53 by Dwight 756-0687

ONE AND TWO FAMILY	PLAN REVIEW	CHECKLIST
Component	Submitted Plan	Findings Revisions Date
STRUCTURAL Footing Dimensions/Depth (Table R403.1 & R403.1(1), /Section R403.1 & R403.1(1))	OK	
Foundation Drainage, Fabric, Damp proofing (Section R405 & R406)	OK Notes - A1	
Ventilation/Access (Section R408.1 & R408.3) Crawls Space ONLY	N/A	
Anchor Bolts/Straps, spacing (Section R403.1.6)	Not shown	OK
Lally Column Type (Section R407)		
Girder & Header Snans (Table R 502.5(2))	3-2x10's	
Built-Up Wood Center Girder Dimension/Type	OK	
MINIMUM JOIST TYPE & DIMENSIONS	2x10's	
First Floor Joist Species Dimensions and Spacing (Table R502.3.1(1) & Table R502.3.1(2))	2x10's	
Second Floor Joist Species Dimensions and Spacing (Table R502.3.1(1) & Table R502.3.1(2))	2x10's	
Attic or additional Floor Joist Species Dimensions and Spacing (Table R802.4(1) and R802.4(2))	2x8 2x8

060331

A2

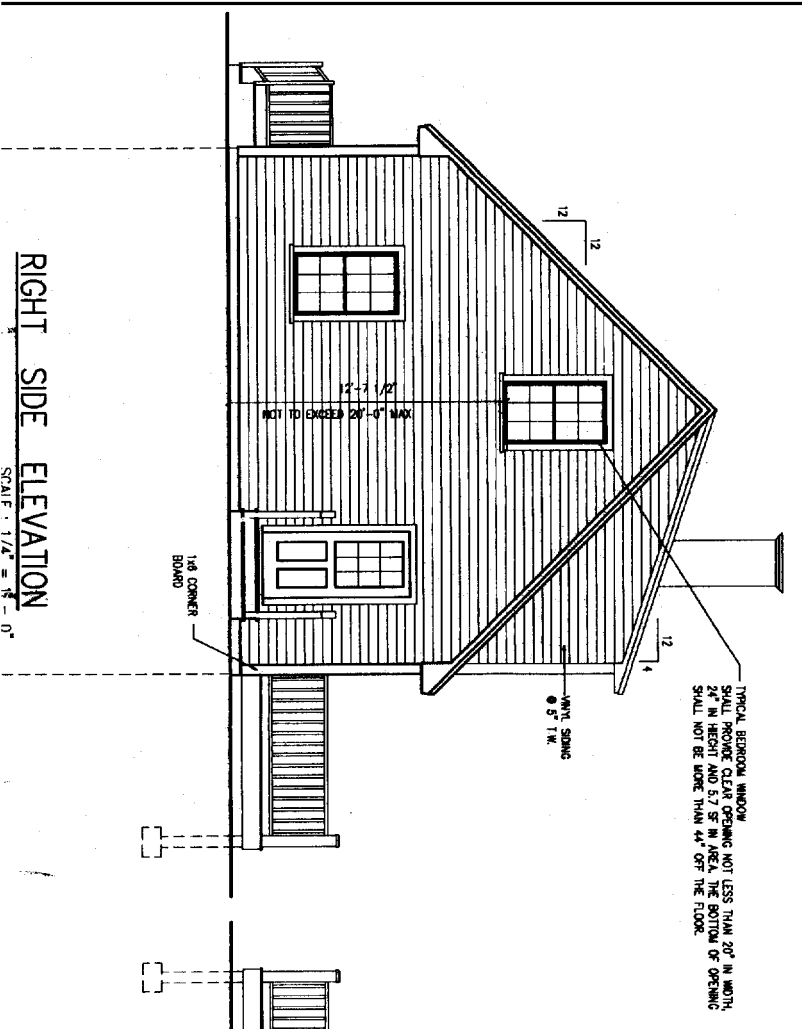
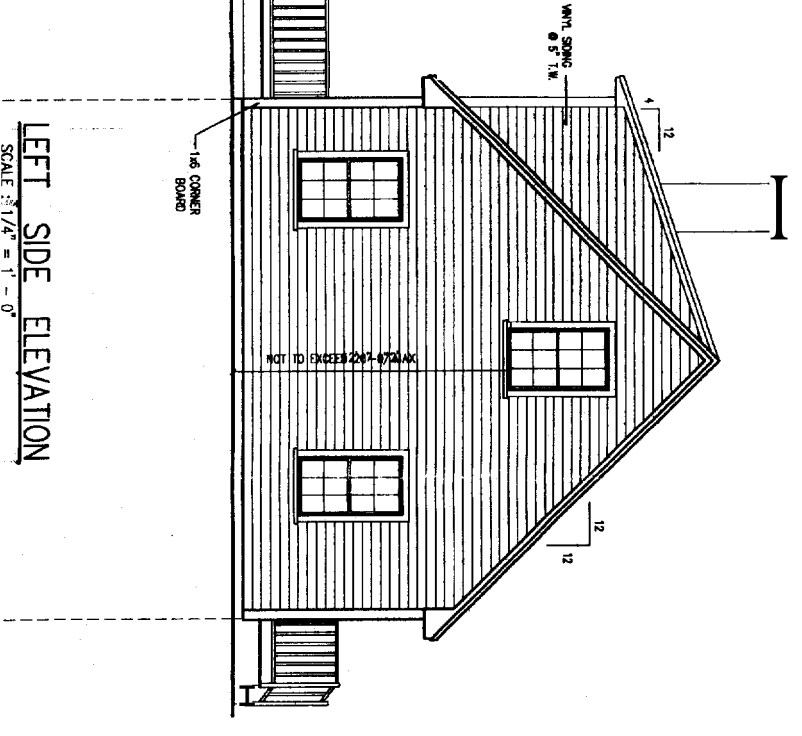
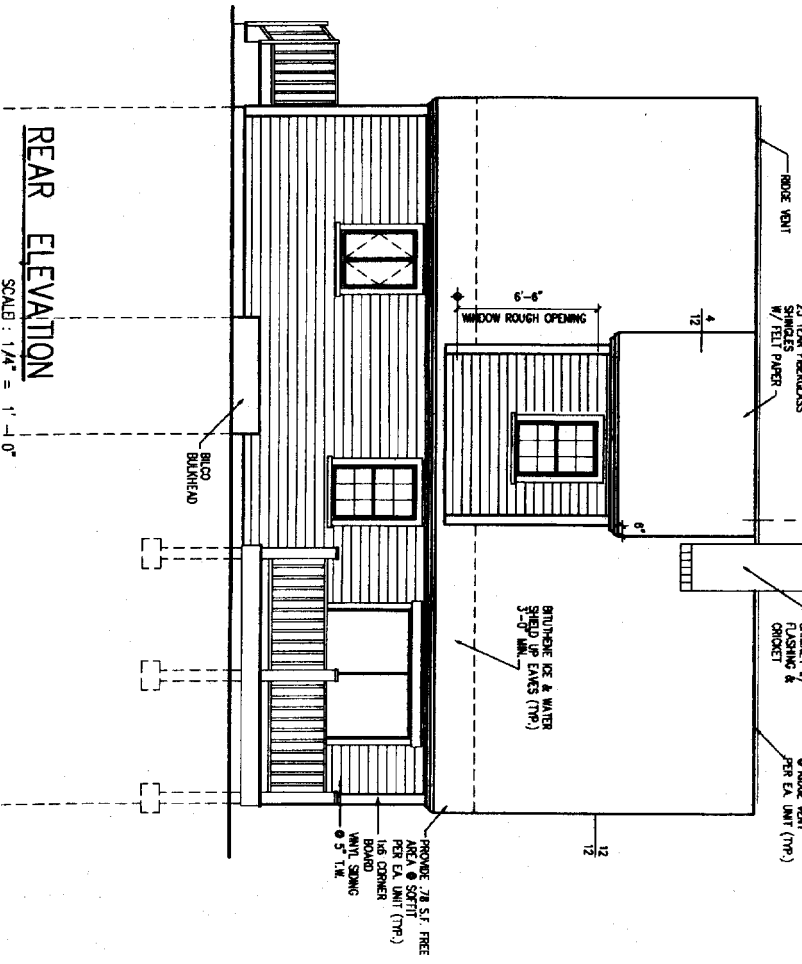
Walls - R-19 } OK Noted on large
 Floor - R-21 }
 A2 - large

Type of Egress System		
Means of Egress (Sec R311 & R312)		
Basement	1	
Number of Stairways	3	
Interior	1	
Exterior	2	
Treads and Risers (Section R311.5.3)	10" T 7 3/4" R	
Width (Section R311.5.1)	3' +	
Headroom (Section R311.5.2)	6' - 8"	
Handrails and Handrails (Section R312 & R311.5.6 - R311.5.6.3)	Not detail - All - Noted All large set	
Smoke Detectors (Section R313) Location and type/Interconnected	Not shown - Condition	
Draftstopping (Section R502.12) and Fireblocking (Section (R602.8)	N/A	
Dwelling Unit Separation (Section R317) and IBC - 2003 (Section 1207)	N/A	
Deck Construction (Section R502.2.1)	Framing of exten. porches - Precast - OK
